Our Ref: TR010039

### **Application by Highways England for an Order Granting Development Consent for the A47 Wansford to Sutton scheme**

### The Examining Authority's written questions and requests for information (ExQ1)

Annex B – Site Compound and Storage Areas

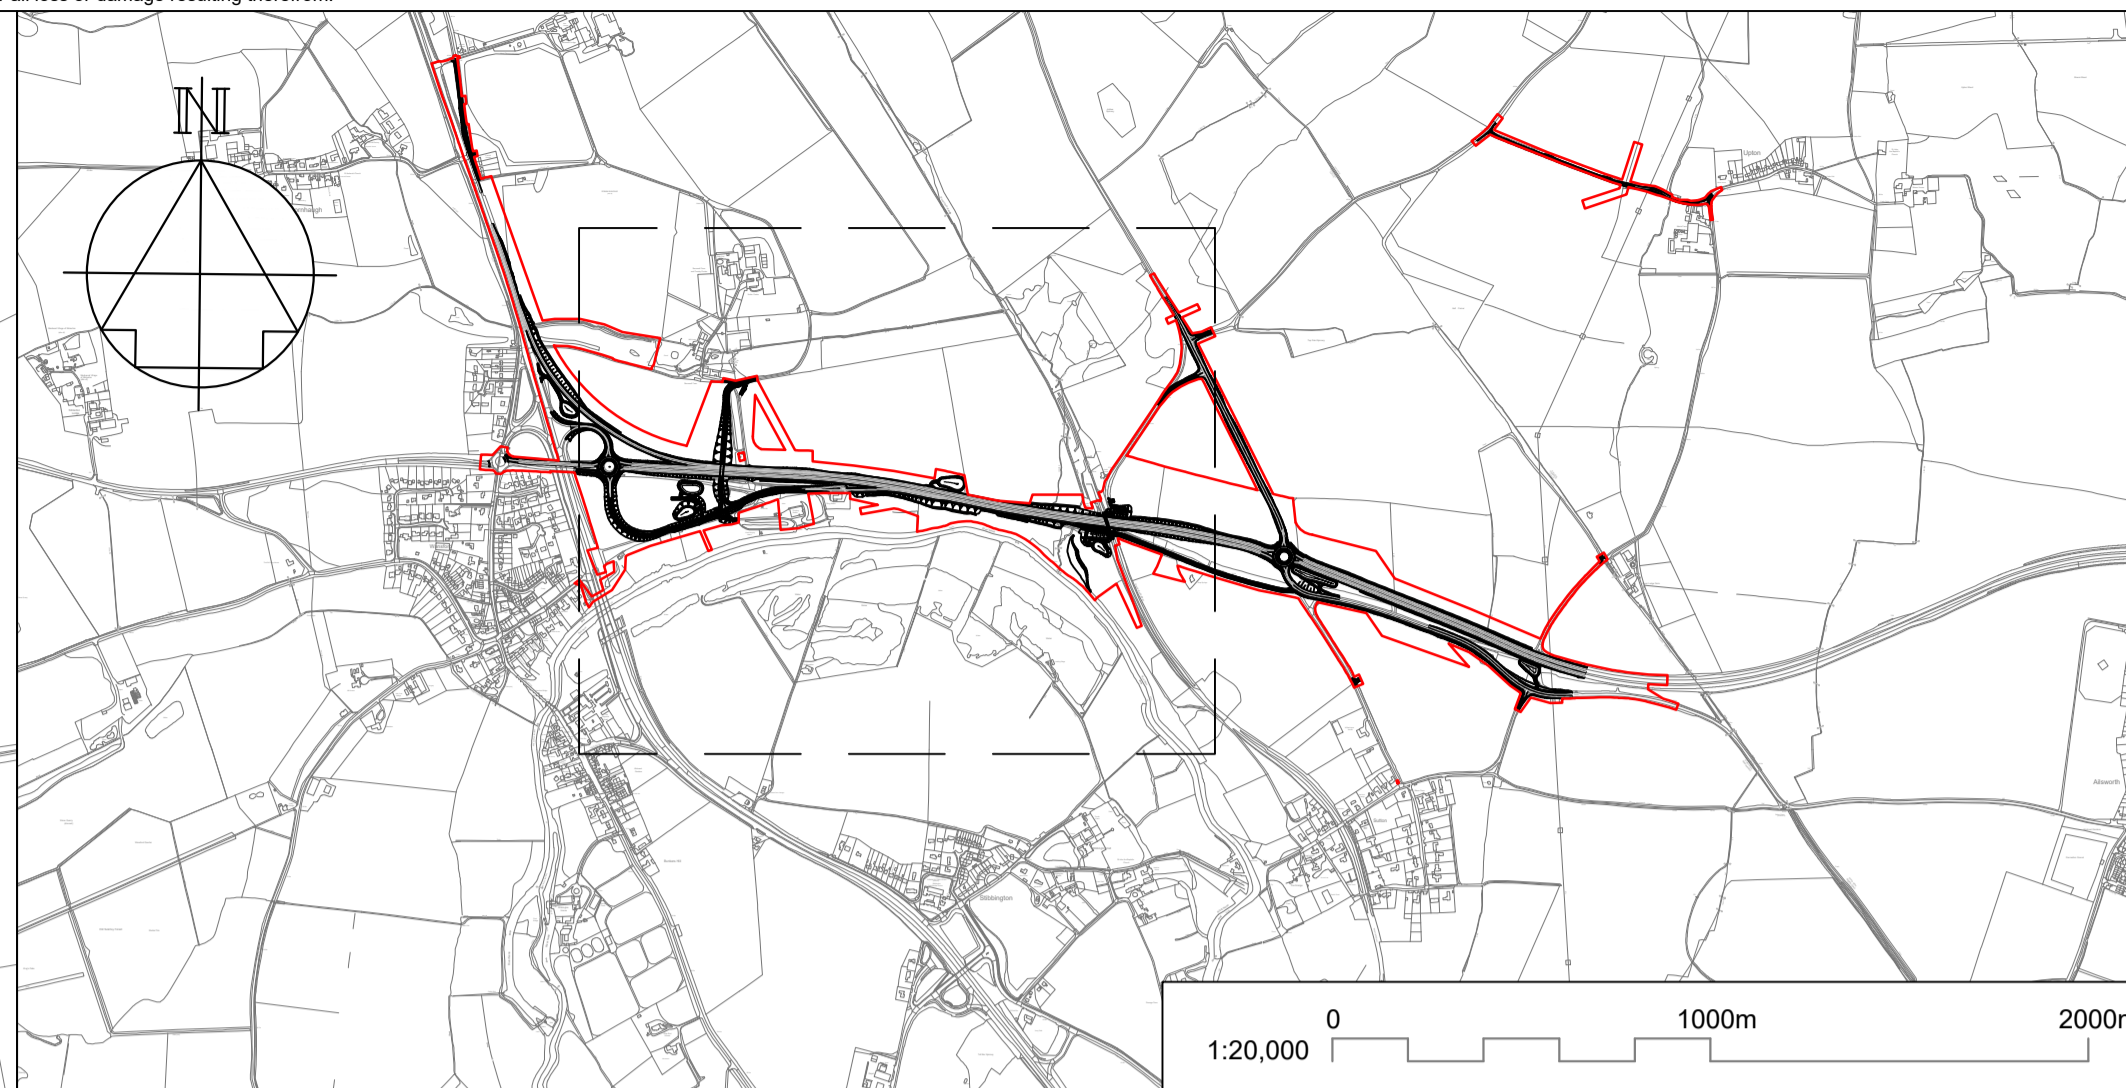
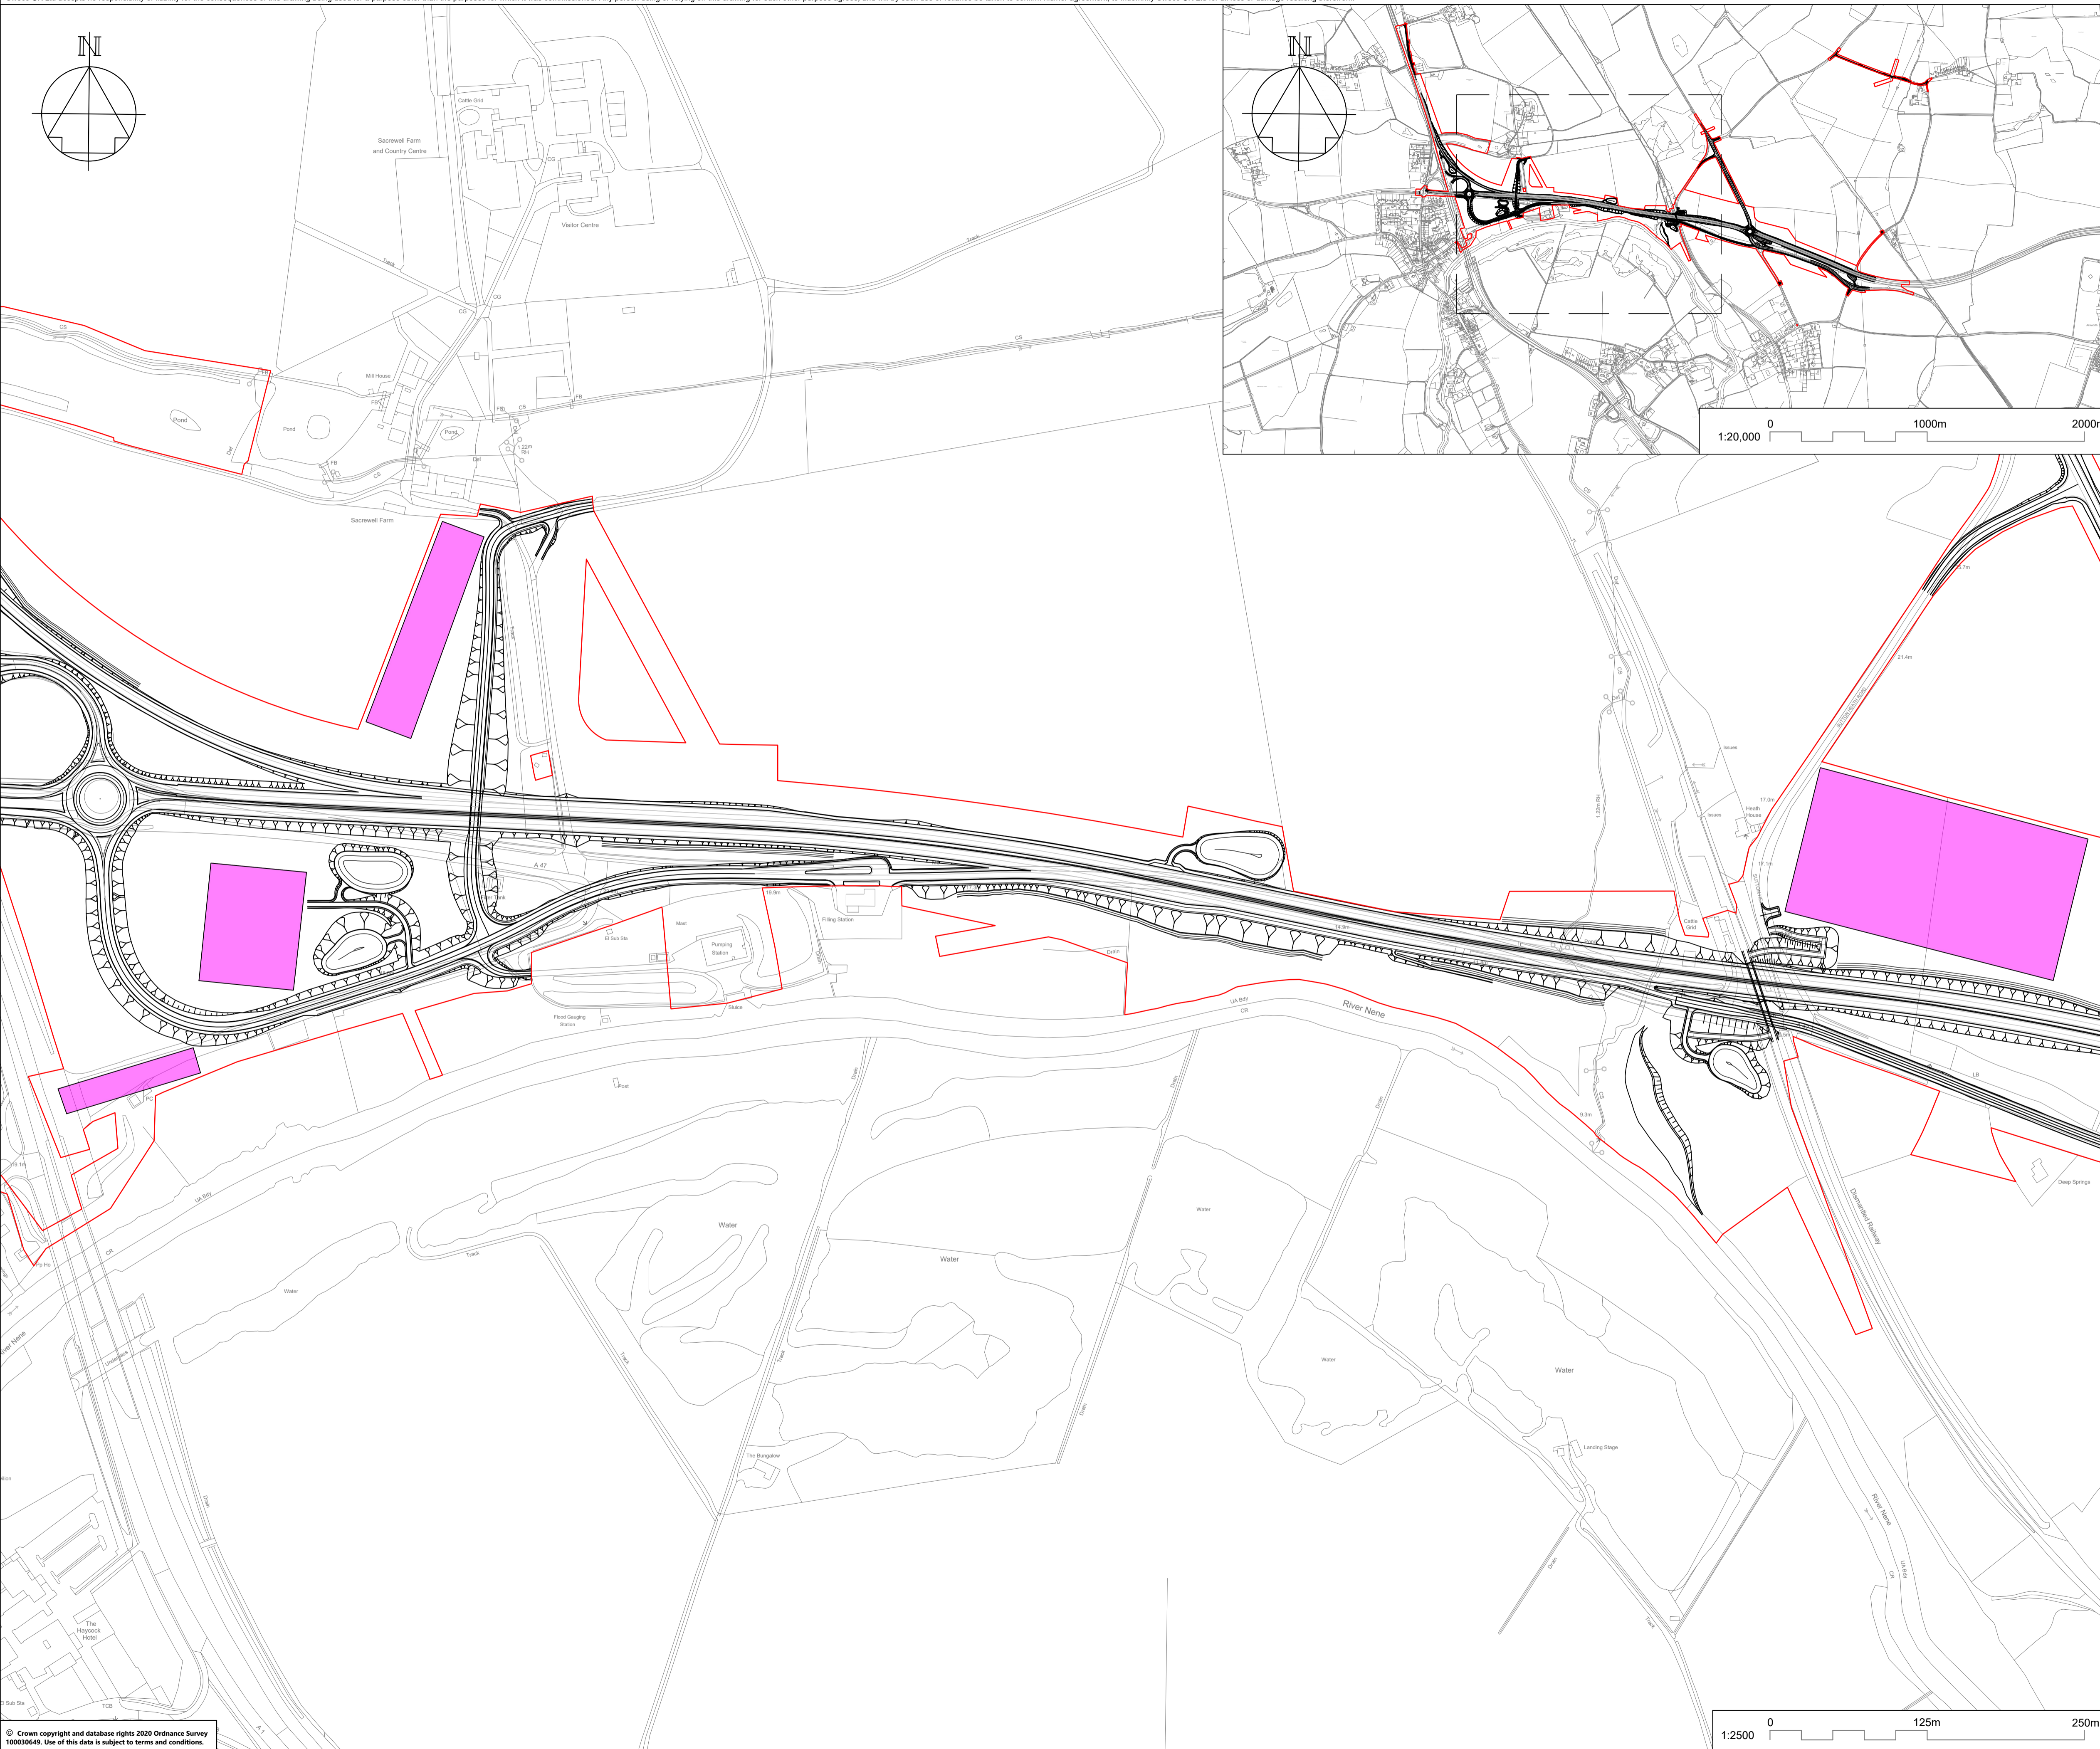
1.0.5.	The Applicant	<p><b>Works Plans</b></p> <p>The key to the original version of the Works Plans [APP-006] included "Construction Compound"; this was not included within the plans themselves and this has been omitted from the key from the revised version [AS-006]. Could the Applicant please clarify the position geographically of any proposed construction compounds.</p>
